**WEST SUSSEX COUNTY COUNCIL
PLANNING SERVICES CONSULTATION**

SUBJECT: WA/73/17/OUT - Outline Planning Application with some matters reserved for up to 157 No. residential dwellings including 30% affordable. This application is a Departure from the Development Plan.

Land East of Wandleys Lane, and West of West Walberton Lane, Fontwell

Drawing Issue Status					
INDICATIVE - FOR INFORMATION					
LAND EAST OF WANDLEYS LANE A27 / A29 WEST ROUNDABOUT JUNCTION GEOMETRY					
Client					
WELBECK STRATEGIC LAND II LLP					
Date of 1st Issue 29.09.17		Designed JHJ	Drawn MJB		
A3 Scale 1:500		Checked GH	Approved GH

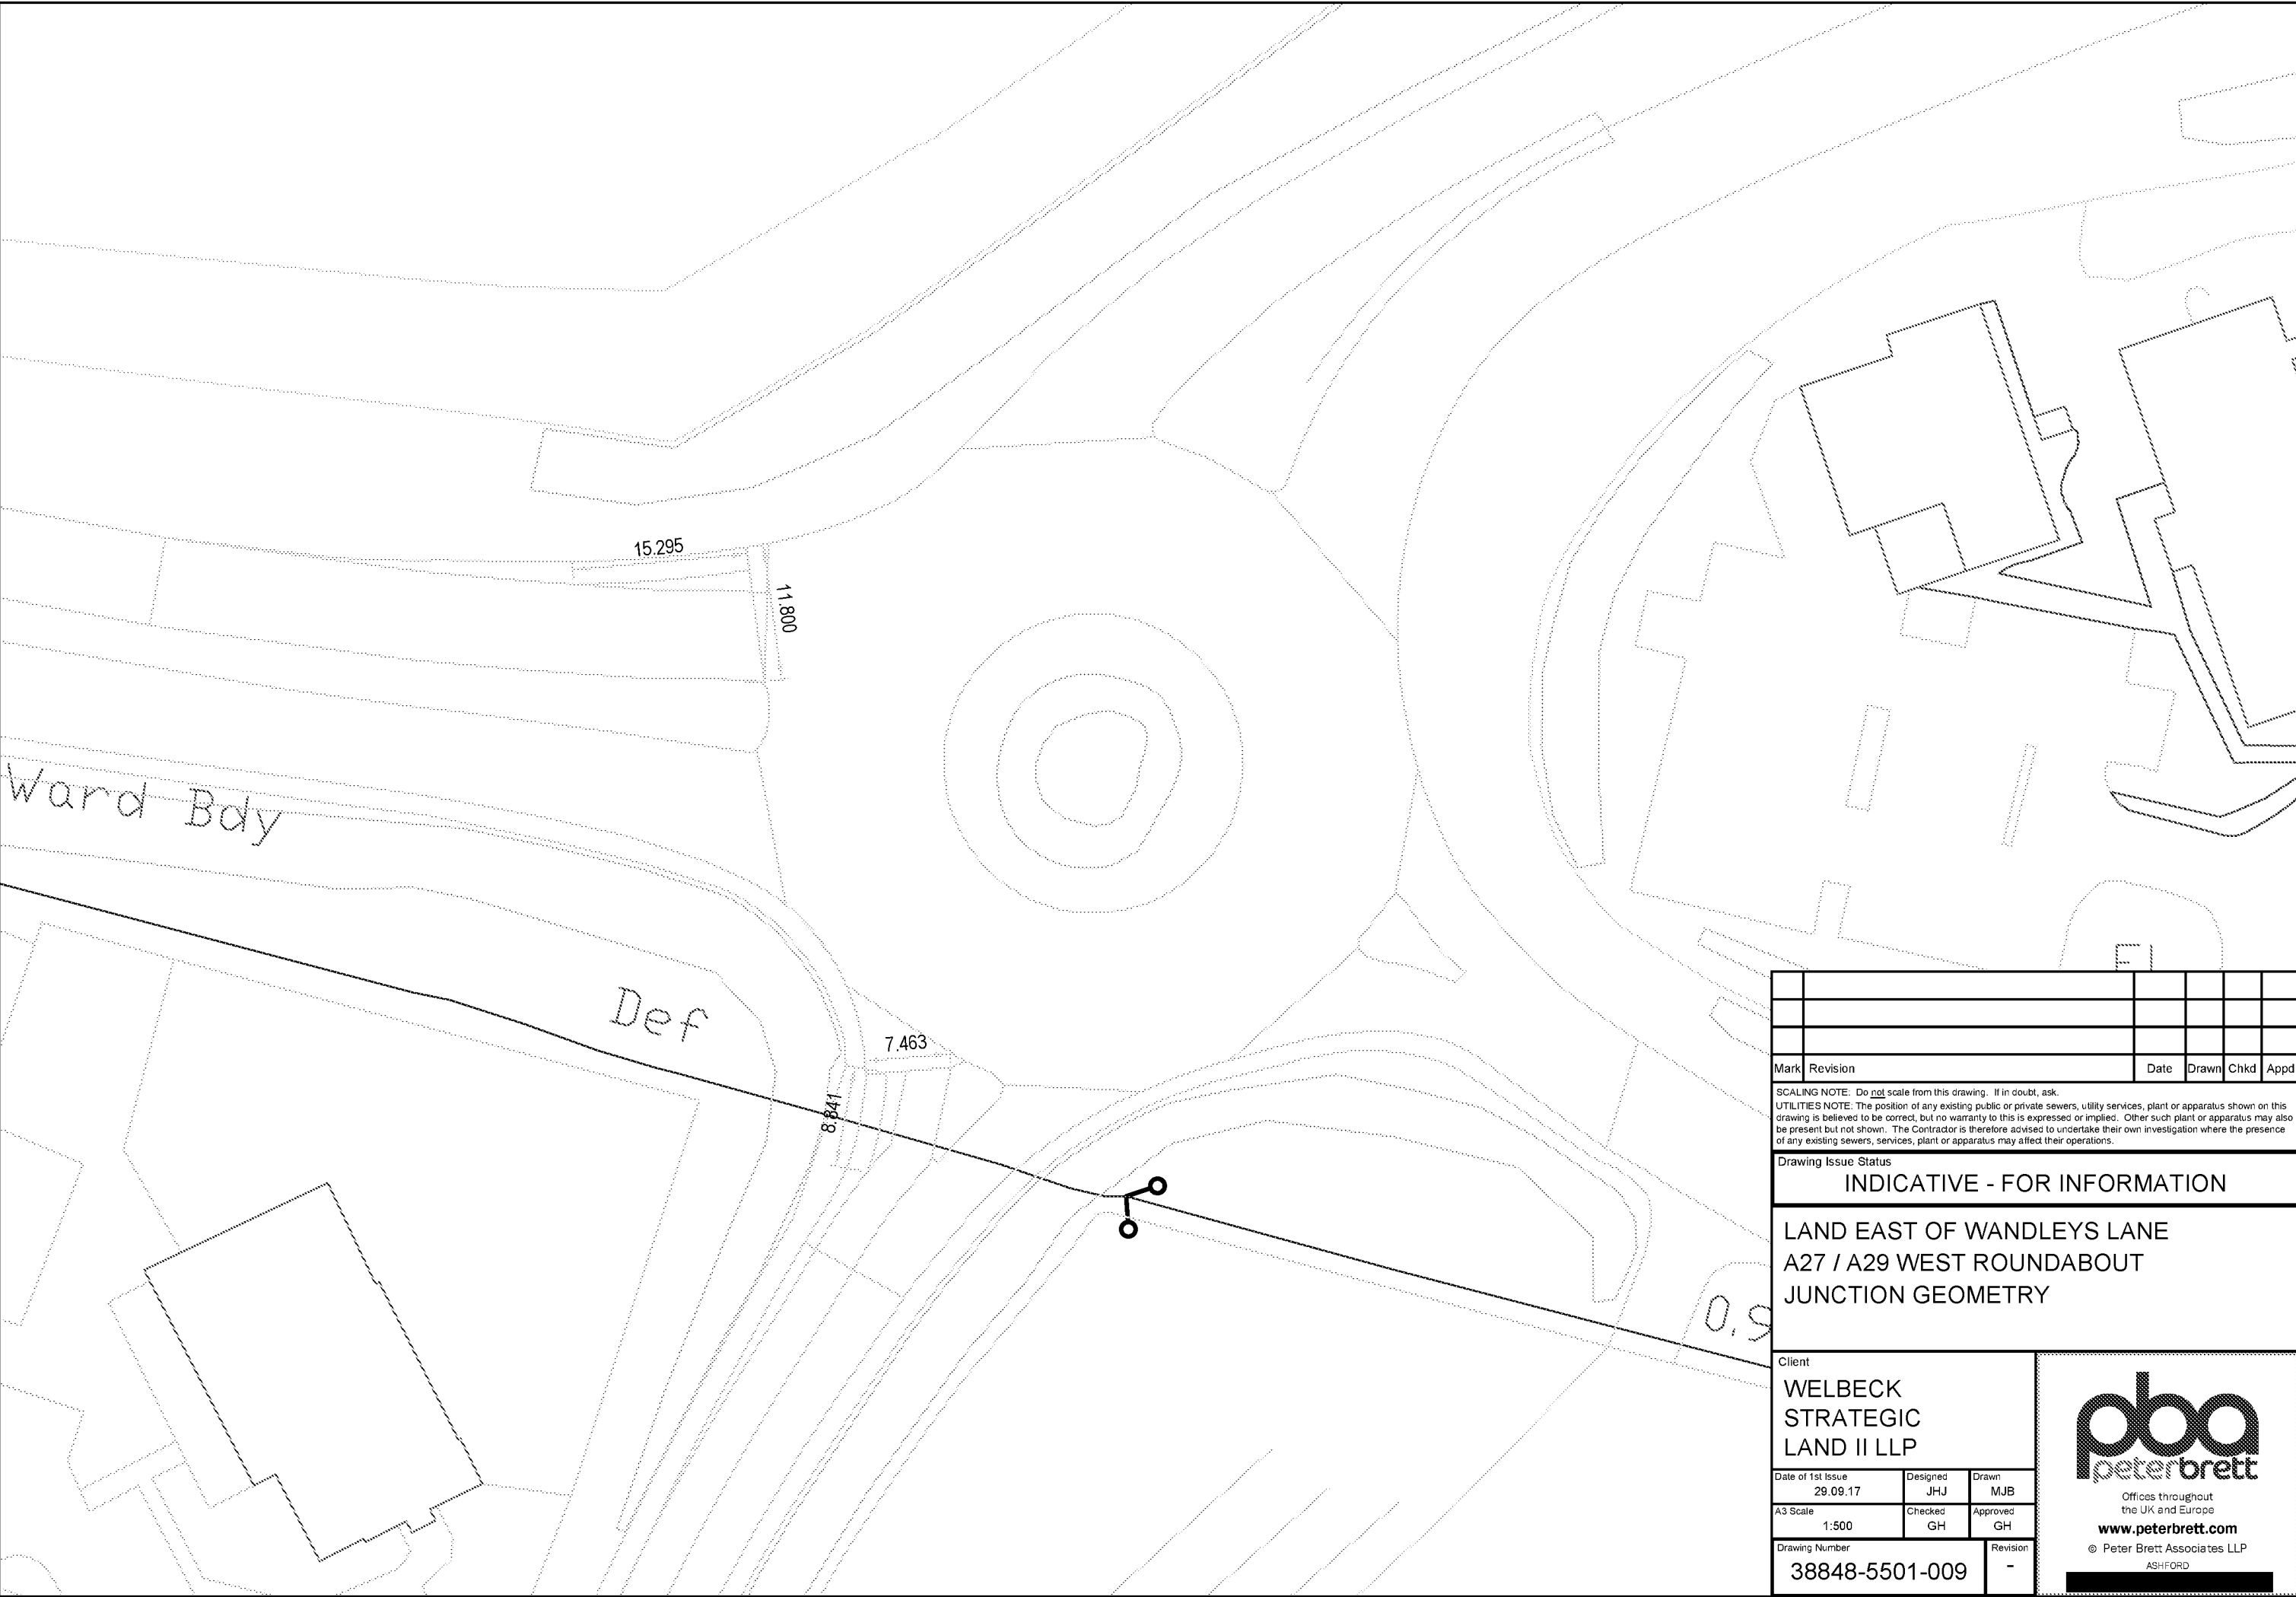
A27 Arundel Road / Arundel Road / A29 Fontwell Avenue

Additional comments will be provided following revised modelling in line with Highways England's comments of the 18th December 2017.

A27 Arundel Road / A29

Additional comments will be provided following revised modelling in line with Highways England's comments of the 18th December 2017.

- The proposal would not achieve safe and convenient access by a choice of means of travel nor encourage and enable and increase in environmentally sustainable means of travel such as walking, cycling and public transport and thereby minimise the impact of car journeys.
- Adequate information has not been submitted to satisfy the Local Planning Authority that the proposal is acceptable in terms of access and would not therefore give rise to increased hazards to highway users.
- Insufficient information has been provided to assess the impacts of the development on the A27/A29 Fontwell junctions.

- Revised modelling for A27/A29 Fontwell east and west junctions;
- Signed designers response for Wandleys Lane improvement;
- Information concerning proposed public transport provision to the site; and
- Information of sustainable transport potential to school and employment opportunities.
